**ST ALOYSIUS COLLEGE REDEVELOPMENT SSD 8669  
SUBMISSION BY THE OWNERS CORPORATION SP1036:  
48 UPPER PITT STREET KIRRIBILLI.**

We have been engaged by the Owners of 48 Upper Pitt Street Kirribilli to examine the Development Application for the St Aloysius 'Plan Magis,' (Master Plan), specifically for the College's Middle and Senior Schools. The College and their consultants have met with us and representatives of the Strata Committee as the plan has evolved. Those attending the briefings understand and support the general strategy, but are concerned about some aspects that will affect views and amenity of residents at 48 Upper Pitt St.

1 South Elevation - Kirribilli Avenue
Scale: 1:200

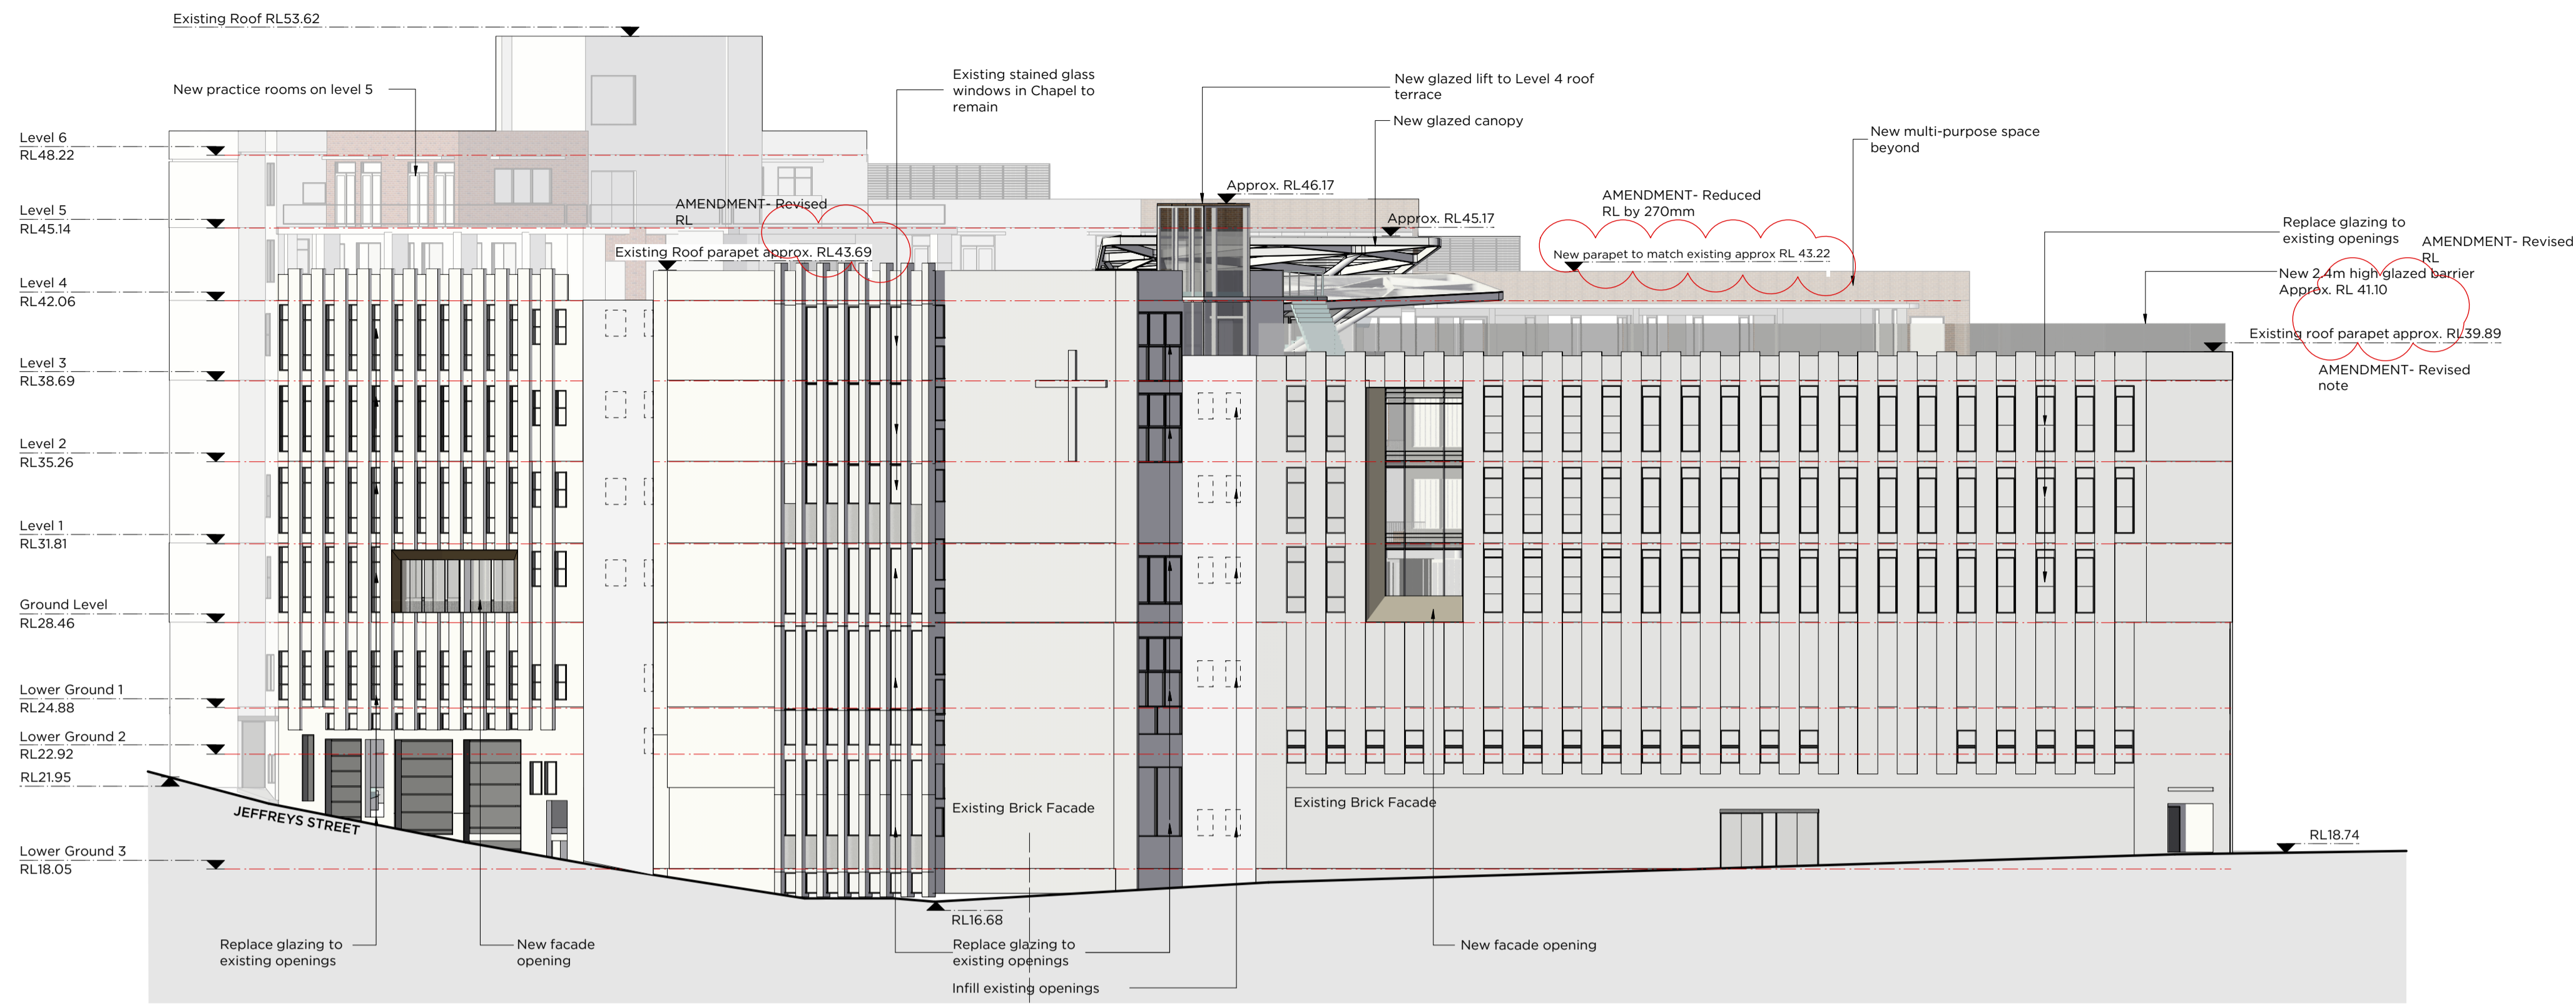
The drawings of the new East Wing on Upper Pitt Street appear to show an increase in the parapet height from the existing RL43.21 to RL43.49, an increase of 0.28m. Similarly, the new façade element above the main entrance appears to be raised from existing RL46.29 to RL46.96 an increase of 0.67m. Both changes appear to be quite unnecessary and would have a severe impact on views from the 2nd floor units, as shown in photograph A.

- Amended parapet heights to the new East Wing and the new main entrance façade element, to keep them at or below the existing heights in the same locations.
- Amended consultation strategy during construction, to include regular coordination between the college, its builder / project manager and a representative of the Strata Committee.
- No sound amplification shall be used on the roof top play areas.
- Hours of use for the roof-top play areas be restricted to normal school hours.
- That out-of-hours use of the roof-top be restricted to New Years Eve, from 5pm on 31st December to 1:30am on 1st January, and Australia Day, 26th January, between 9am and 9pm.
- That roof-top shade structures and mature planting be kept below the view lines from the sitting positions in all 3rd floor units at 48 Upper Pitt St.

3 Section 3
 Scale: 1:200

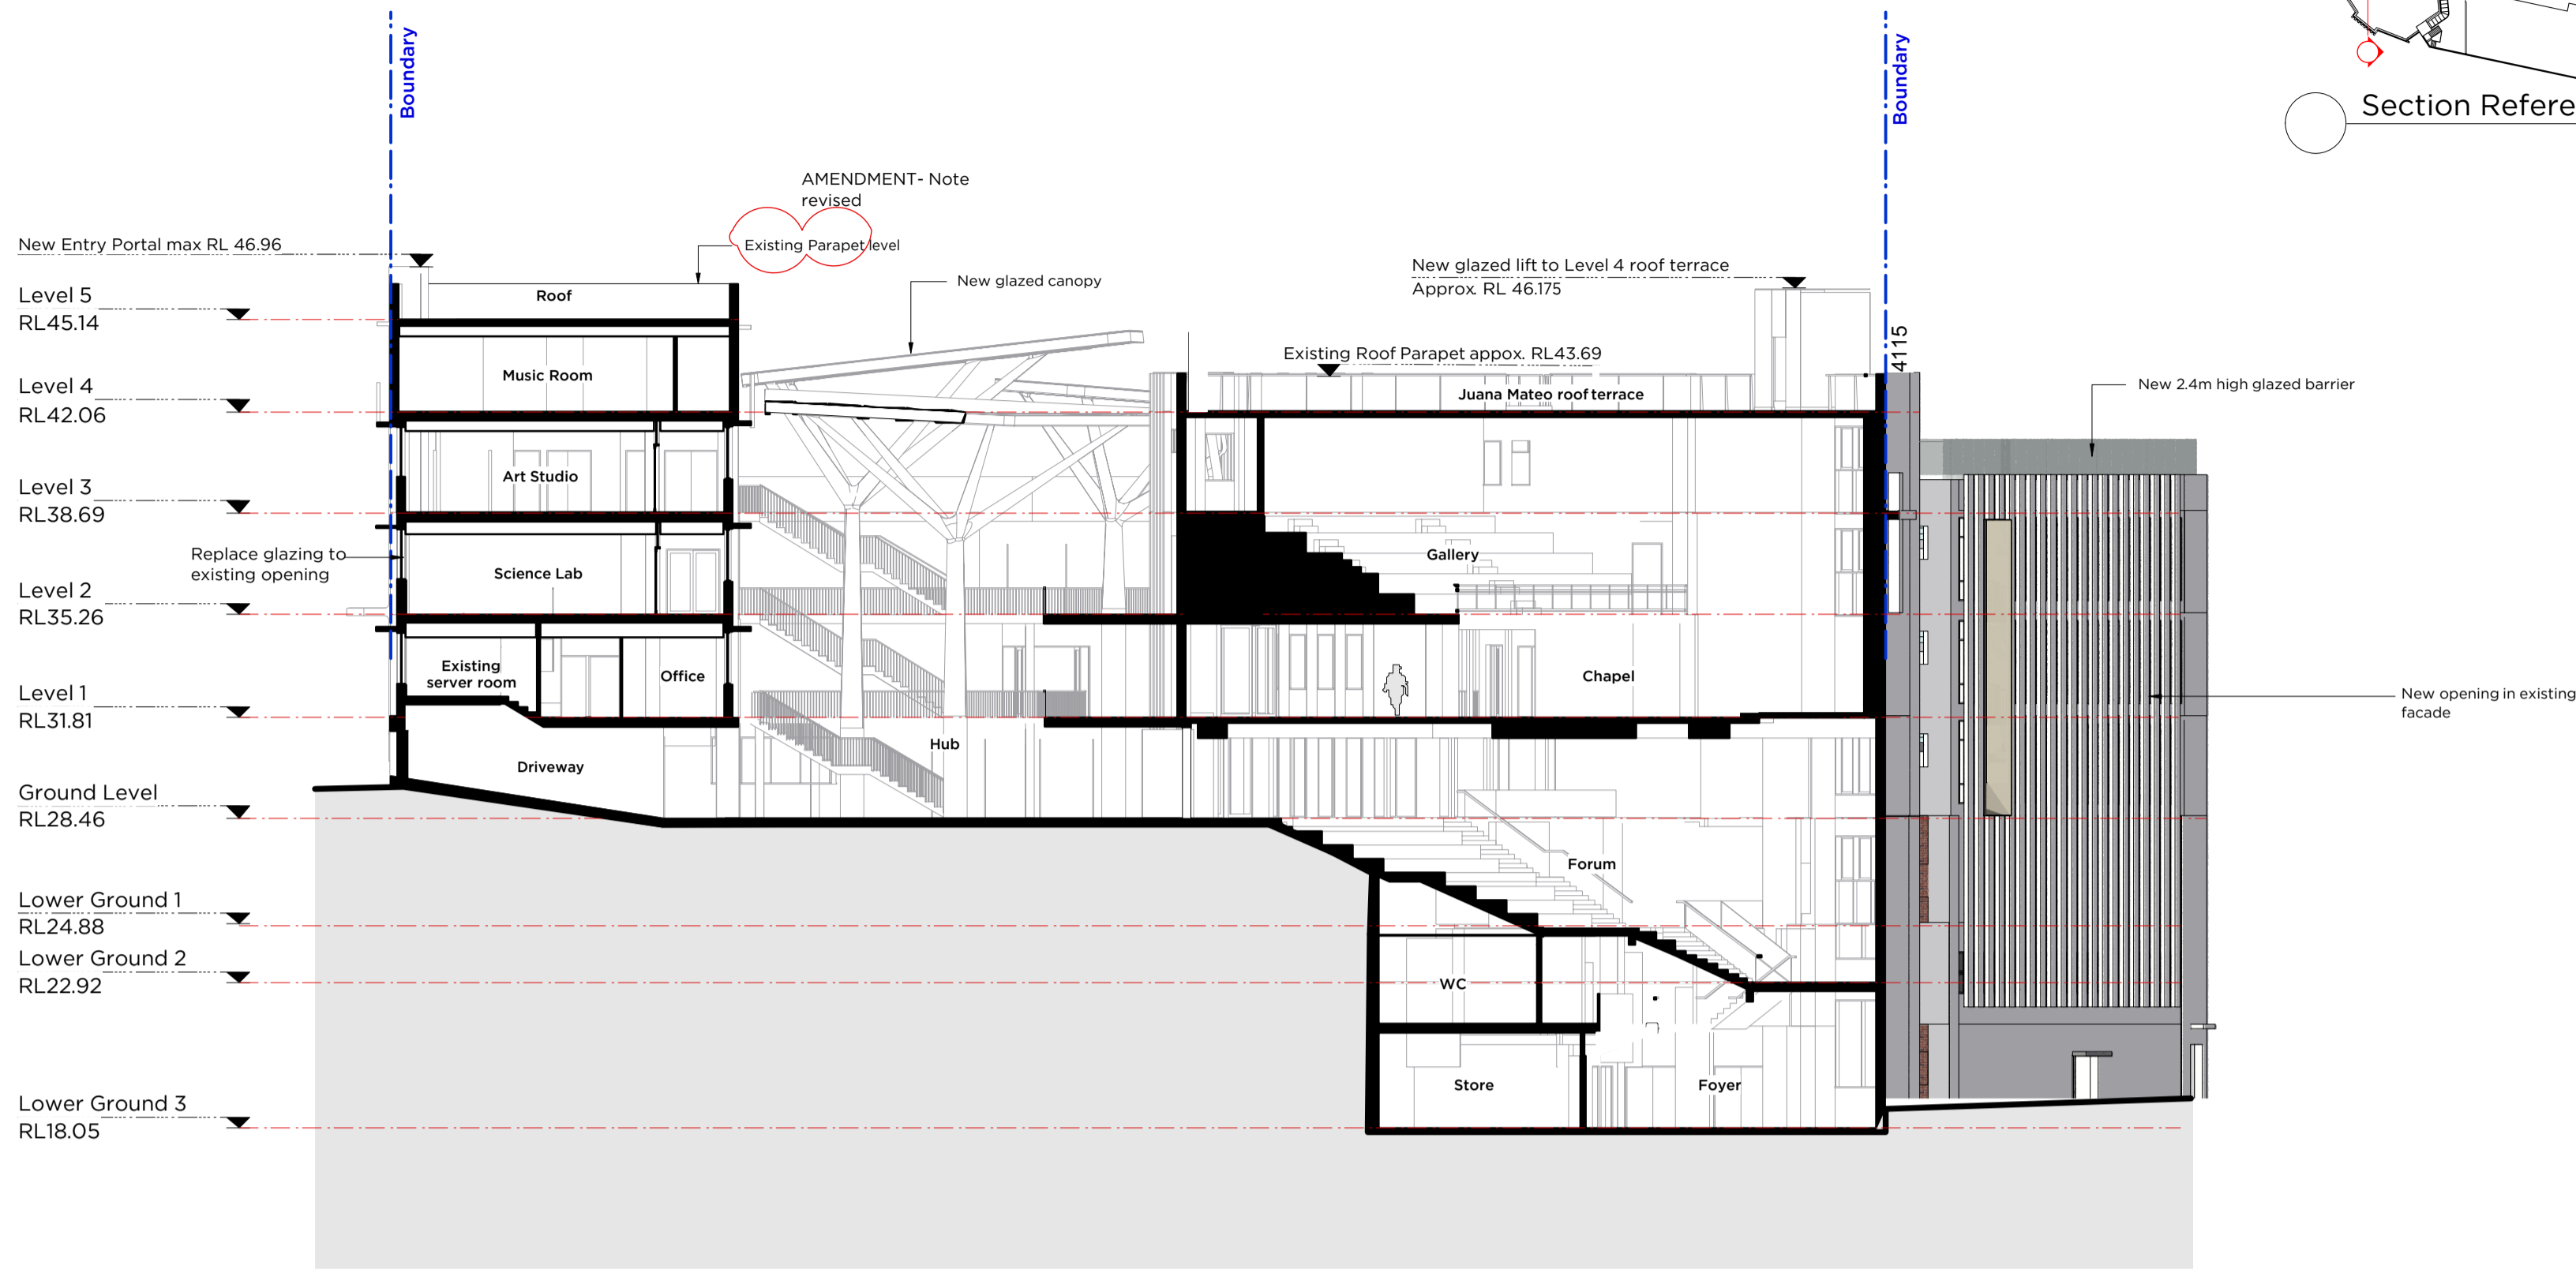
Some of the parapet heights are not entirely clear, or may contain errors. For example Section 3 on sheet DAU301 shows parapet to the new East Wing as RL46.64 rather than the intended RL43.49 for that part of the section.
